Office of Water

**Section 75W Project Modification Application
Apex Gas Exploration Project (09_0161 – MOD 1)**

**NOW COMMENTS ON ENVIRONMENTAL ASSESSMENT
APEX GAS EXPLORATION PROJECT (09_0161 – MOD 1)**

Figure 2
Location Plan AI19

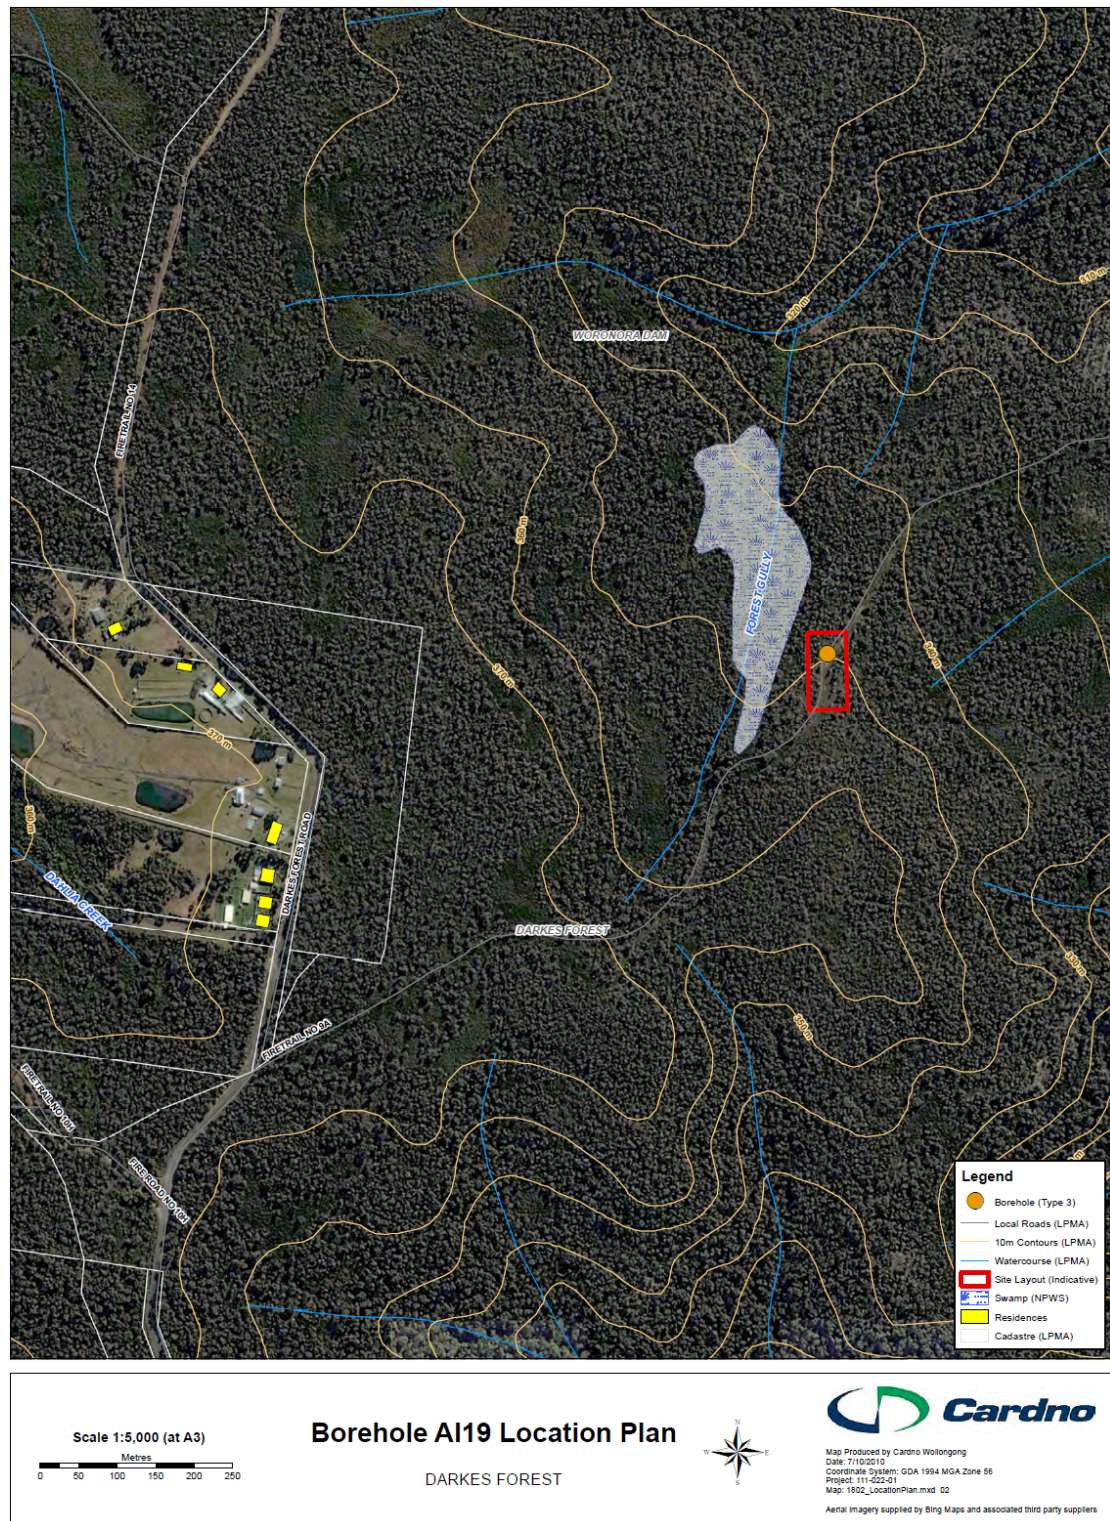
The proponent has stated (Page 29) that the proposed development footprint does not interfere with any riparian zones, as both the proposed drill pad and access road are on a ridgeline well away from streamlines. However, Figure 2, on page 15, shows a significant upland swamp on Forest Gully, which may be within 40m of the proposed site. The potential for damage to this swamp, particularly as a result of water quality / sedimentation issues, is of concern. These swamps are typically dependent on groundwater (Groundwater Dependent Ecosystems), and the lowering of groundwater levels as a result of drilling activities is also of concern. NOW recommends the Environmental Management Plan for the site referred to in Action 32 of the project commitments should address the protection of this swamp, utilising appropriate erosion and sedimentation controls, and that sumps and storage facilities for the containment of drilling fluid and other chemicals be constructed in such a manner as to preclude any contamination of groundwater in the area.
